SADDLEHORN RANCH FILING NO.3

A PARCEL OF LAND LOCATED IN SECTION 3

JOB NO. 25142.05
 APRIL 24, 2023
 SHEET 1 OF 5

PCD FILE: SF-23-004

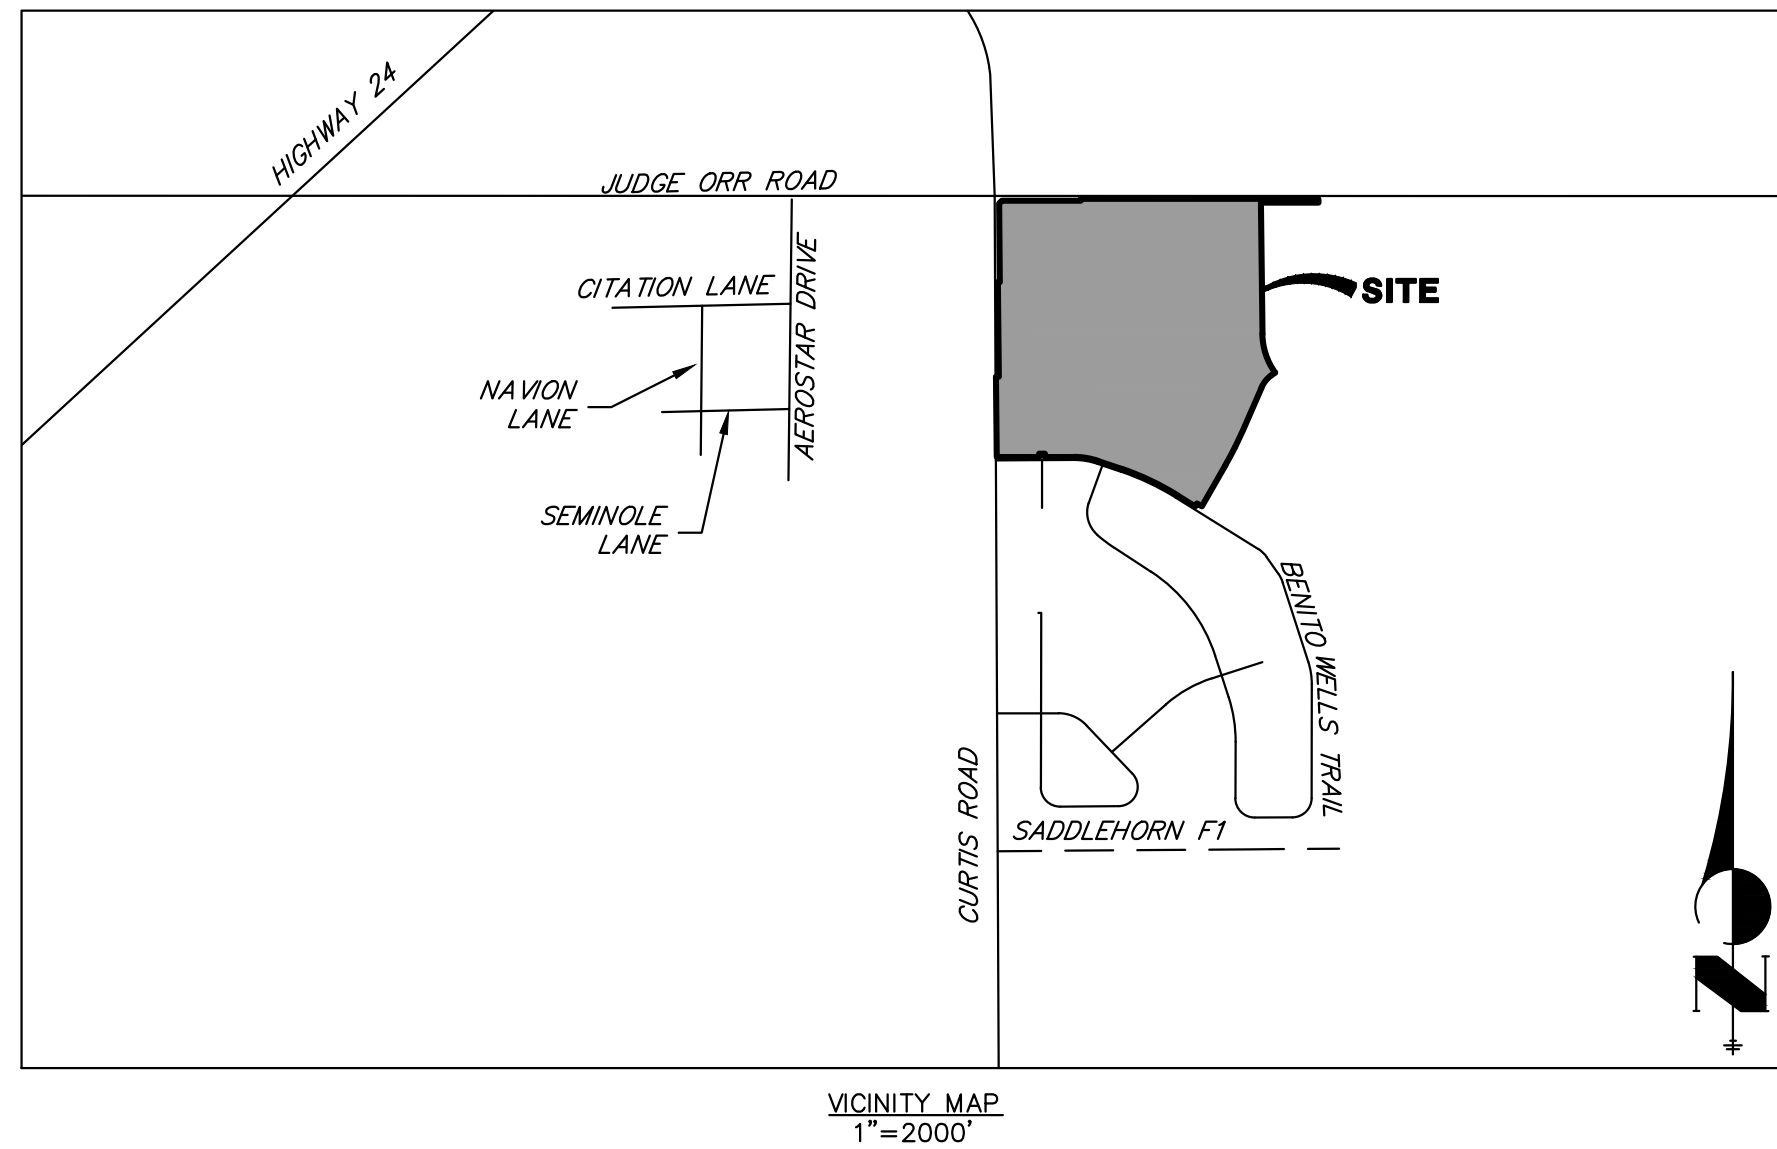
Review 1 comment unresolved: include the quarter section

Unresolved: Area does not match closure sheets

JR Response: Comment addressed.

JR Response: This area is correct. I am providing a closure report of the boundary.

JOB NO. 25142.05
APRIL 24, 2023
SHEET 4 OF 5

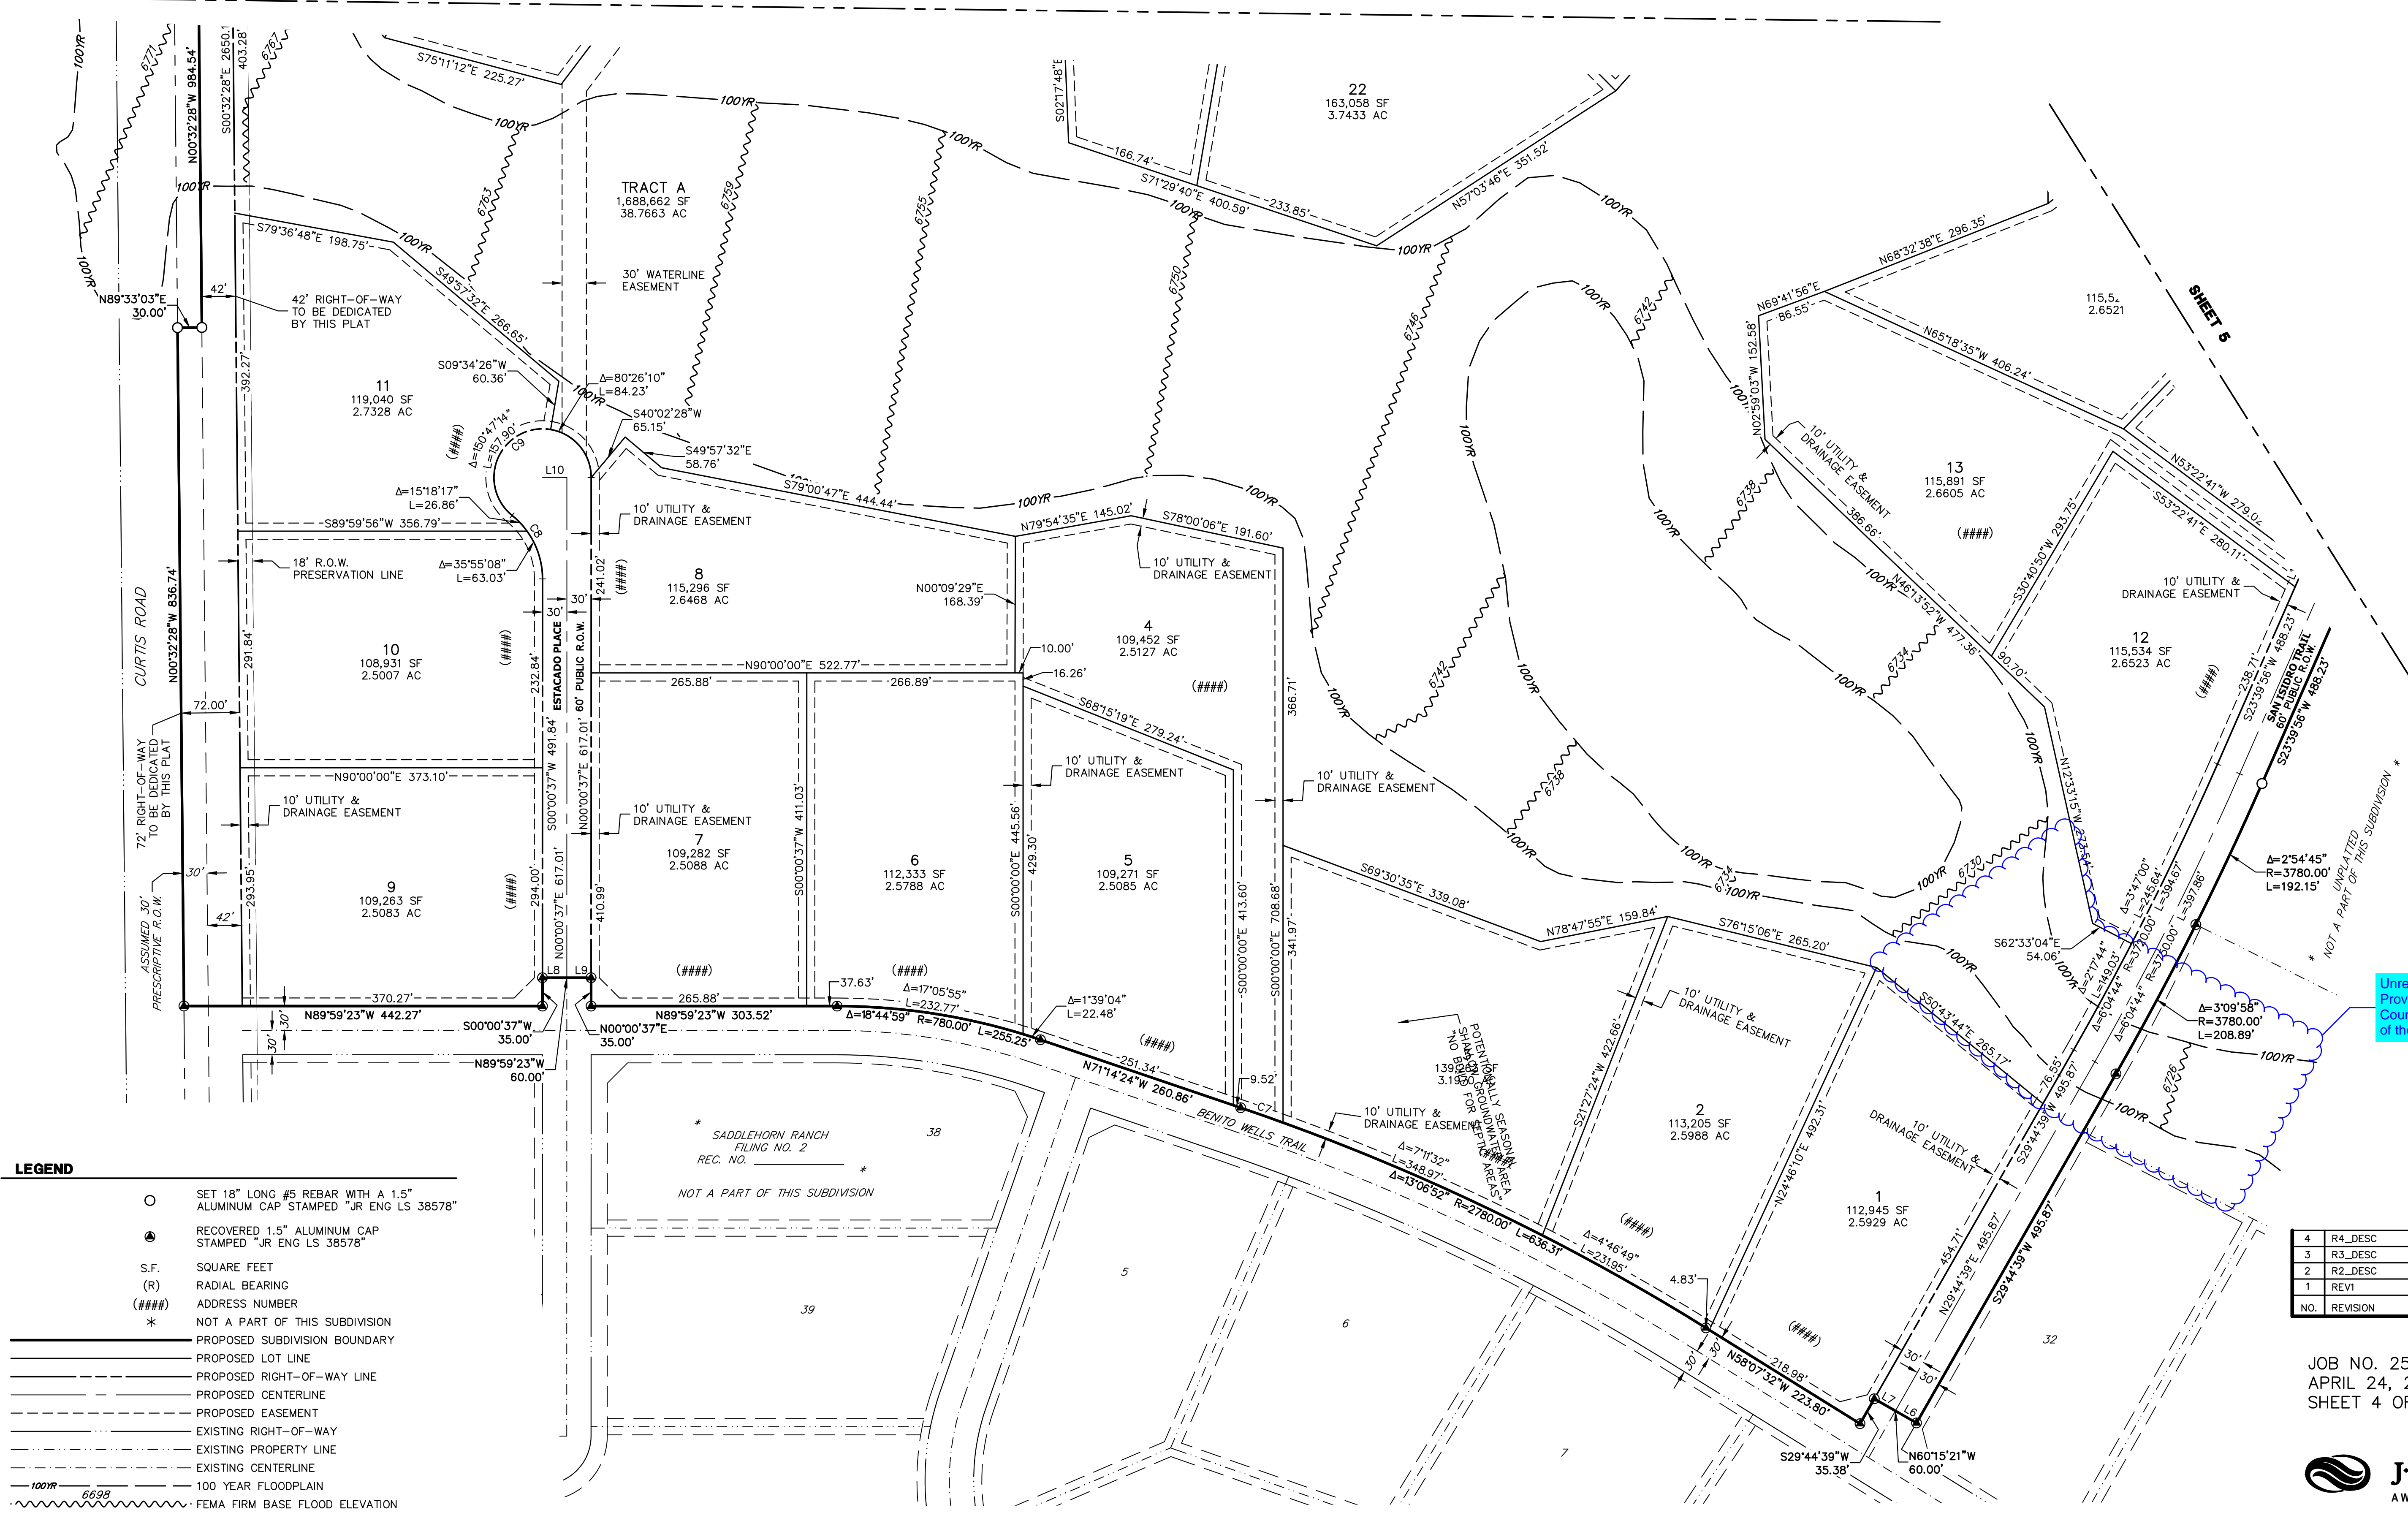
Unresolved:
Correct closure calculations to follow north boundary.

Unresolved:
Include any geohazard areas from Figure 6 in soils & geology report

Unresolved 1st review comment:
include sign easements for any subdivision entryway signage.

JR Response: A new closure report will be provided with this submittal.

JR Response: Comment addressed & updated legend.

JR Response: Sign easements added.

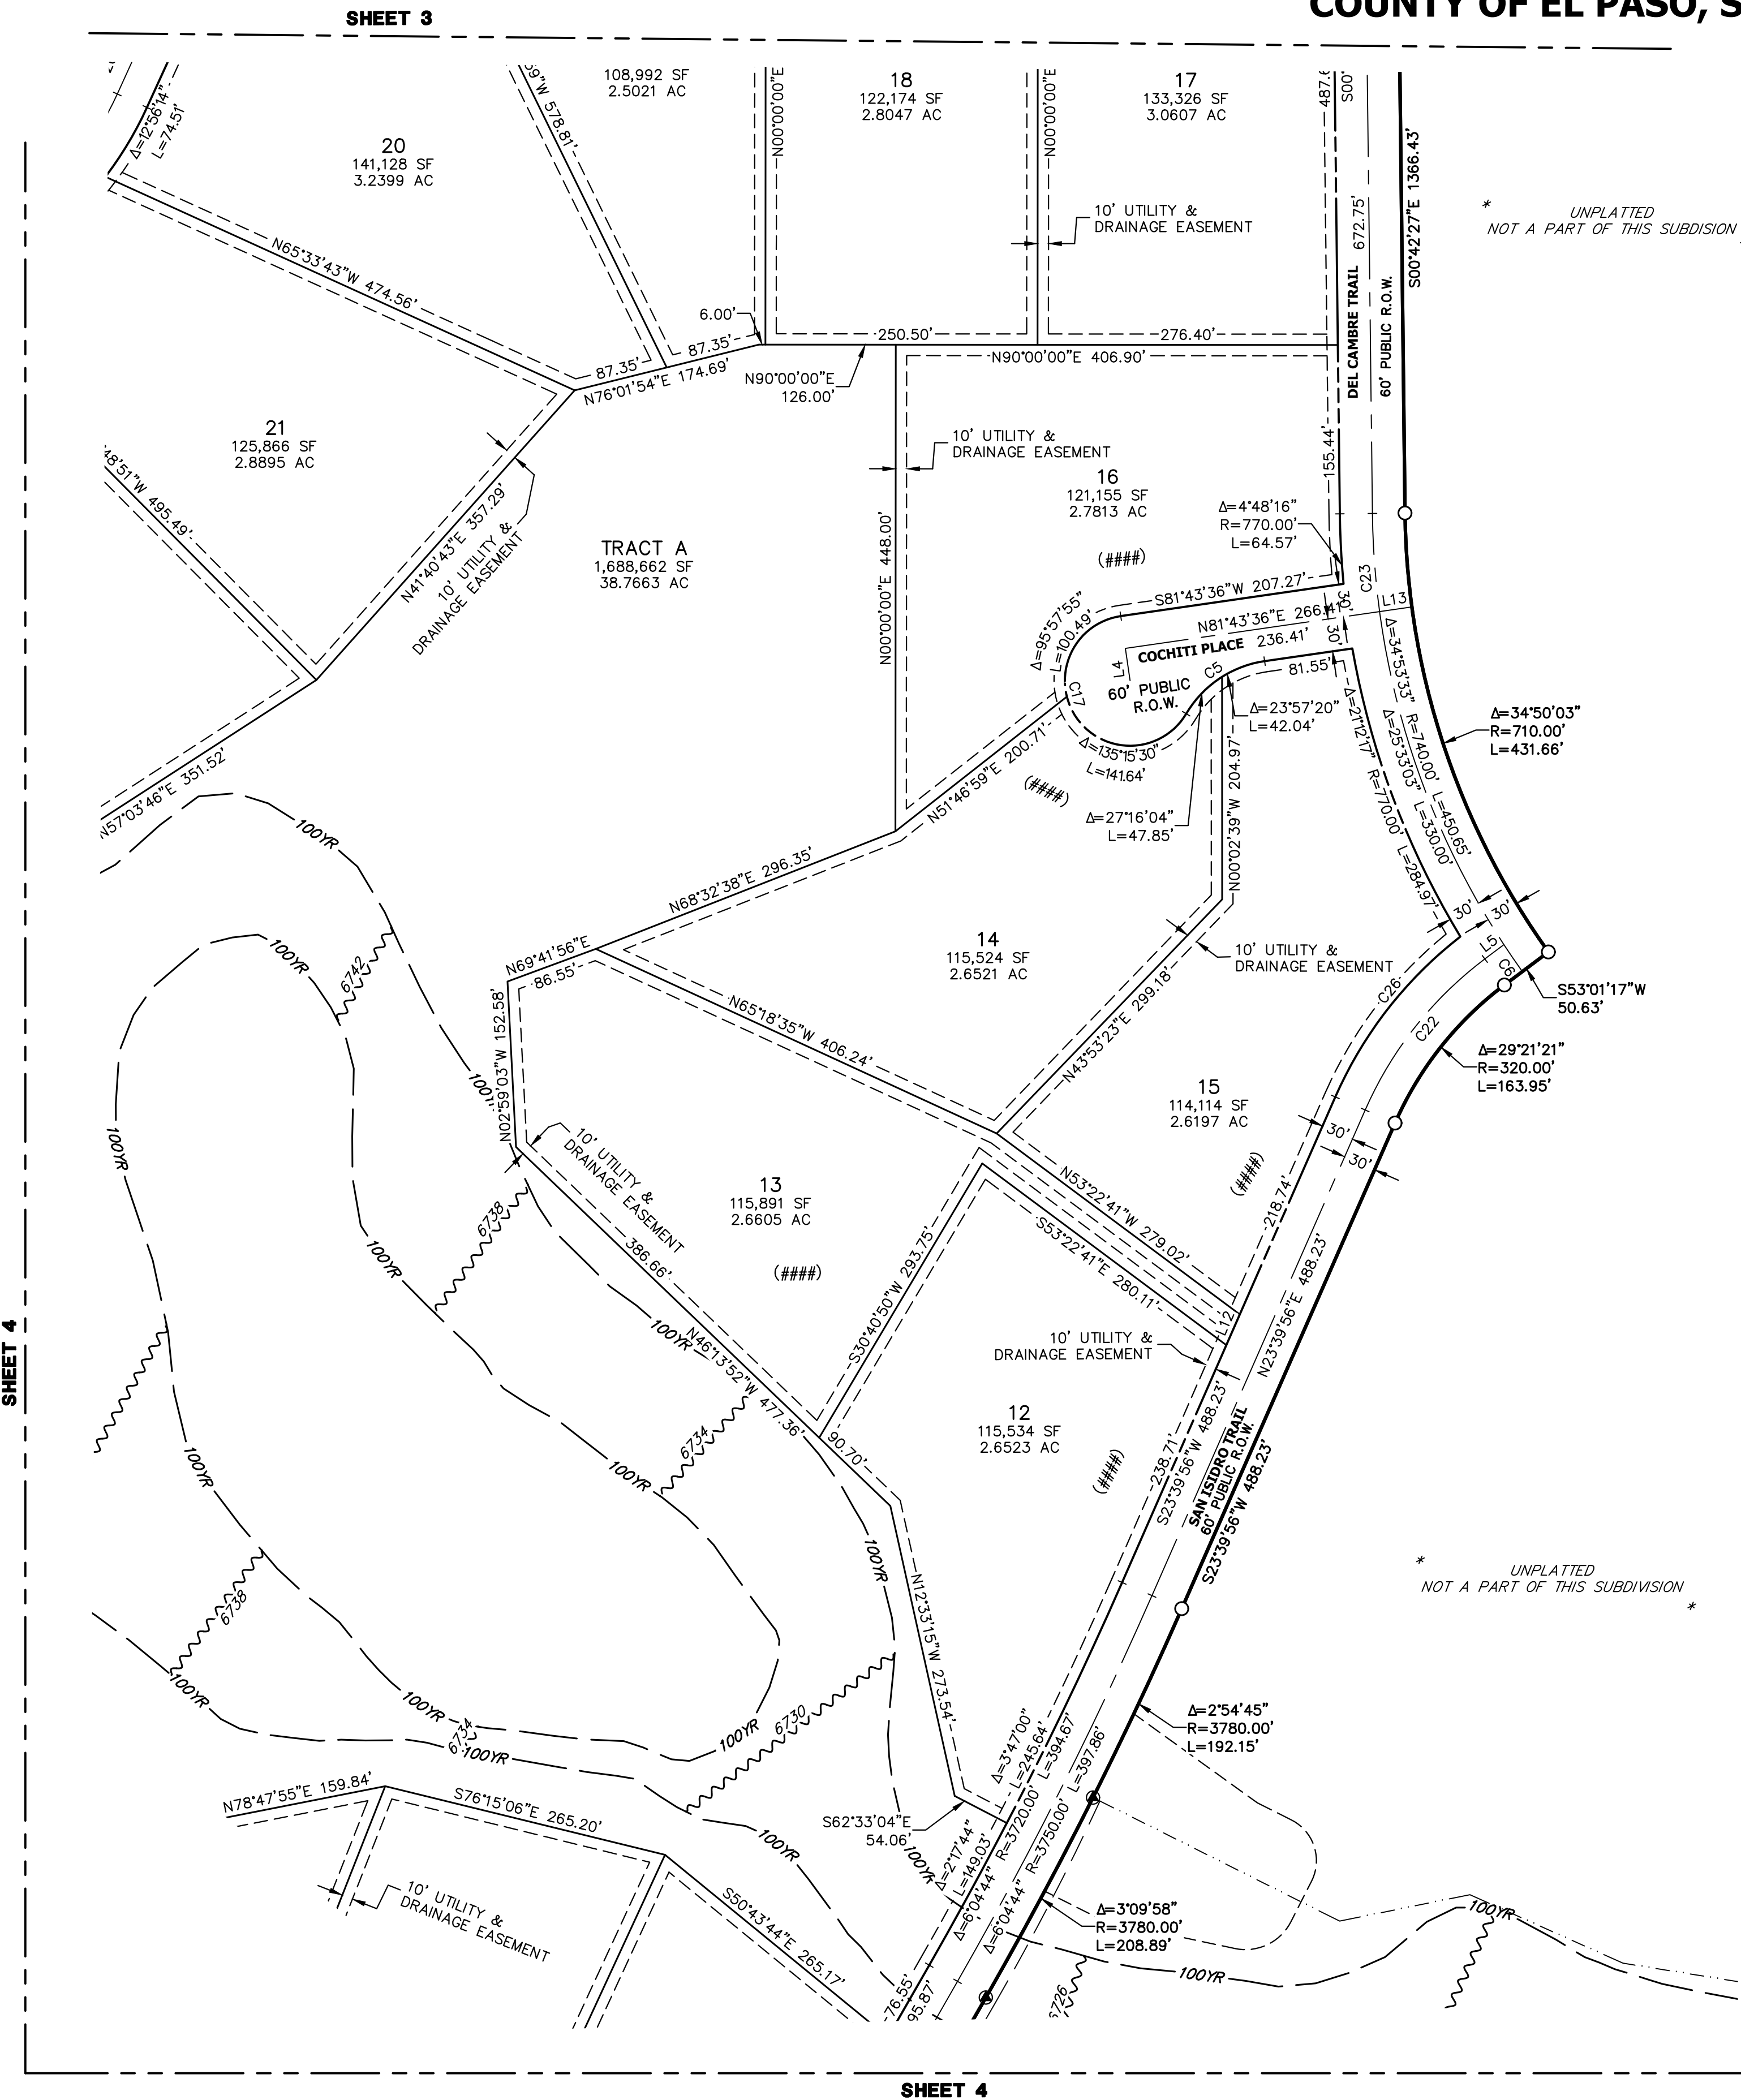
Unresolved:
Provide separate easements for County acceptance and maintenance of the culverts, wingwalls and riprap

In general note #7 we show that all of Tract A is for Drainage Purposes. Does this satisfy this comment?
